From: [REDACTED]
Sent: 21 July 2026 10:21
To: OxfordshireSRFI
Subject: Oxfordshire Rail Freight - TR050008
Attachments: holding objection - Oxford rail freight .pdf

The Planning Inspectorate
c/o QUADIENT, 69 Buckingham
Avenue, Slough, SL1 4PN**RE: Holding Objection – Application TR050008 - The Oxfordshire Strategic Rail Freight Interchange and Highways Order 202****Location: Land adjacent to the Chiltern Main Line Railway, southwest of Junction 10 of the M40 motorway, Oxfordshire**

I am writing to submit a Holding Comment to the above Nationally Significant Infrastructure Project (NSIP) application. These comments are submitted for and on behalf of the British Horse Society (BHS); local representatives may also submit responses.

ACCESS AND RIGHTS OF WAY PLANS SHEET 04

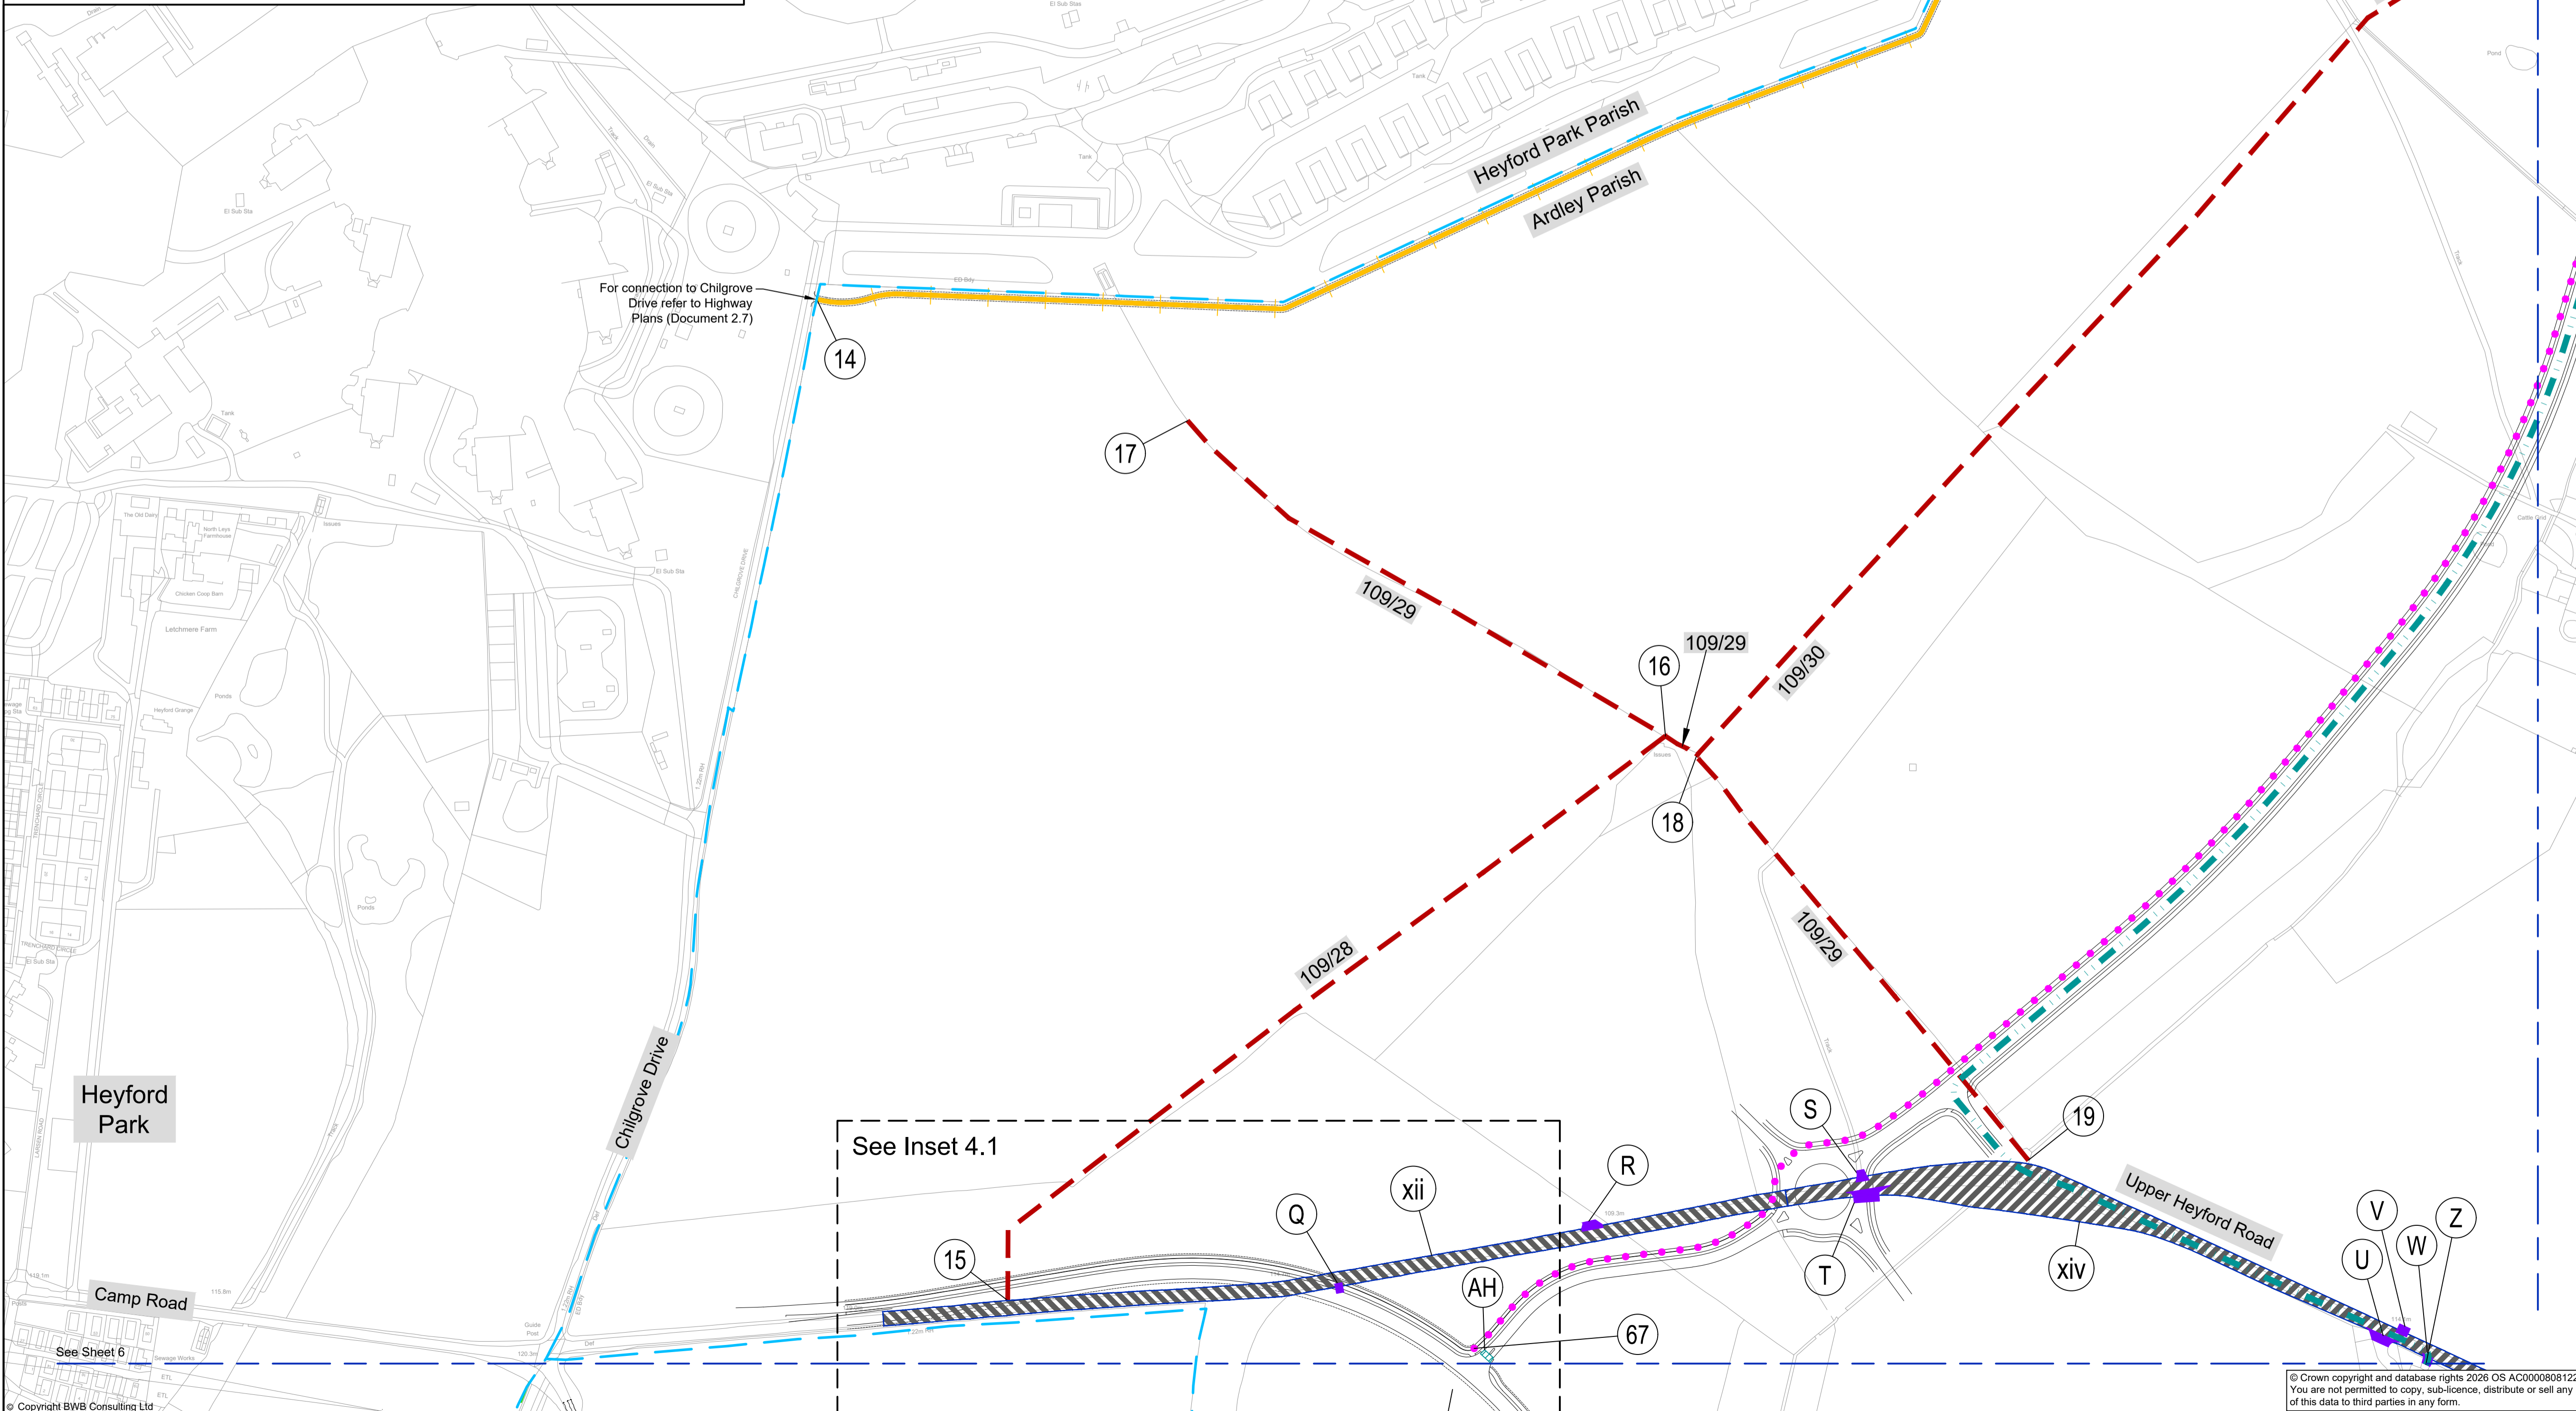
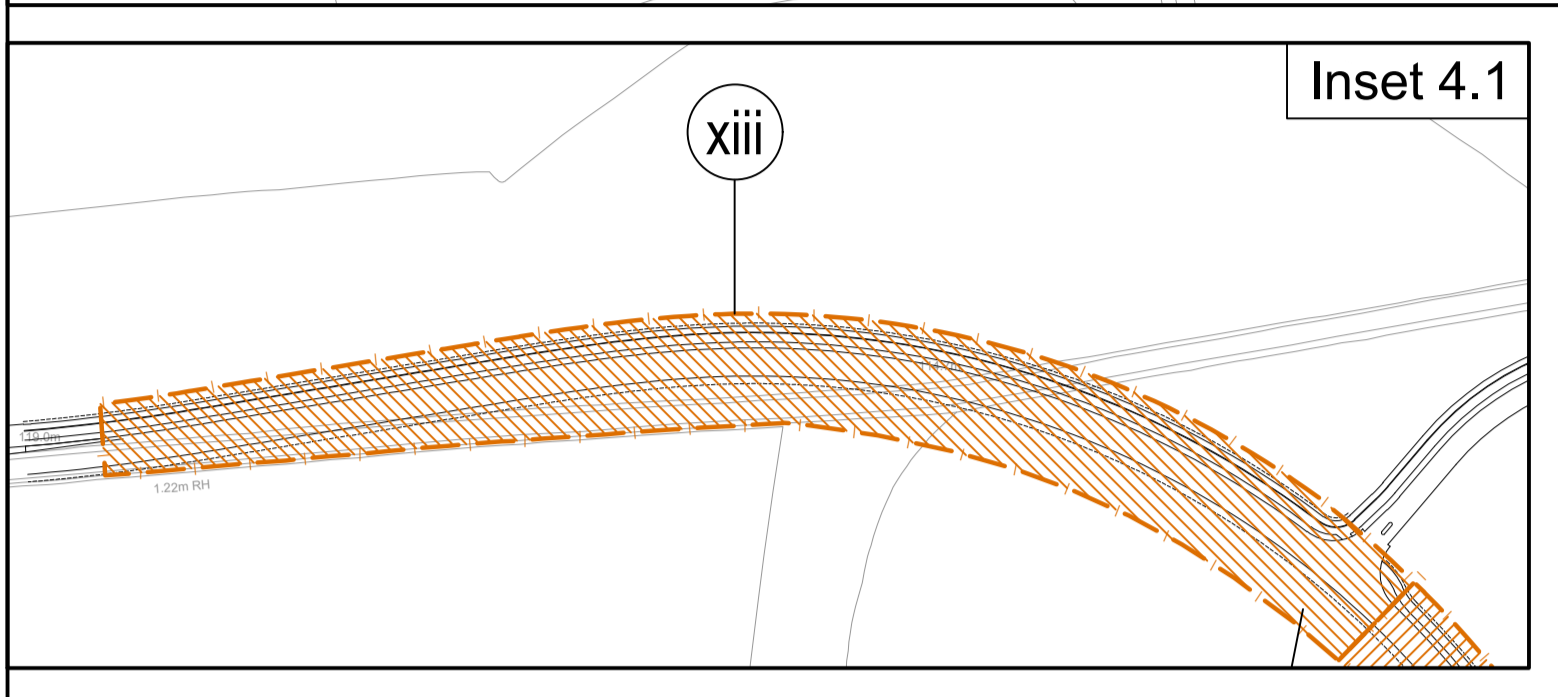
The BHS would like to express strong concern regarding the permanent stopping up of definitive public rights of way as detailed in Schedule 5, Part 1 of the draft Development Consent Order (dDCO), specifically affecting Public Bridleways 109/28, 109/29 (part), 109/30, and 109/26 (part).

The application proposes to replace these definitive routes with "permissive shared use cycle tracks" running through the estate road network (under Requirement 9). Permissive status does not carry the permanent, long-term statutory protection of a designated public right of way, which could leave equestrians vulnerable to future access changes. Furthermore, Schedule 5, Part 2 permanently extinguishes a section of Public Bridleway 109/29 with no substitute provided. We would like to see all re-provided peripheral routes legally dedicated as permanent Public Bridleways to ensure long-term network security.

Within Schedule 5, Part 3 and other sections of the dDCO, new and substitute routes are frequently classified as "Cycle Tracks". We are concerned that routes designed primarily for bicycles are often finished with hard, sealed materials (such as tarmac). These surfaces can be dangerously slippery for equines and lack the necessary shock absorption for safe riding. We would like to see a formal commitment ensuring that any shared-use route expected to accommodate equestrian traffic is constructed with an equestrian-safe surface in accordance with BHS guidelines for multi-user routes.
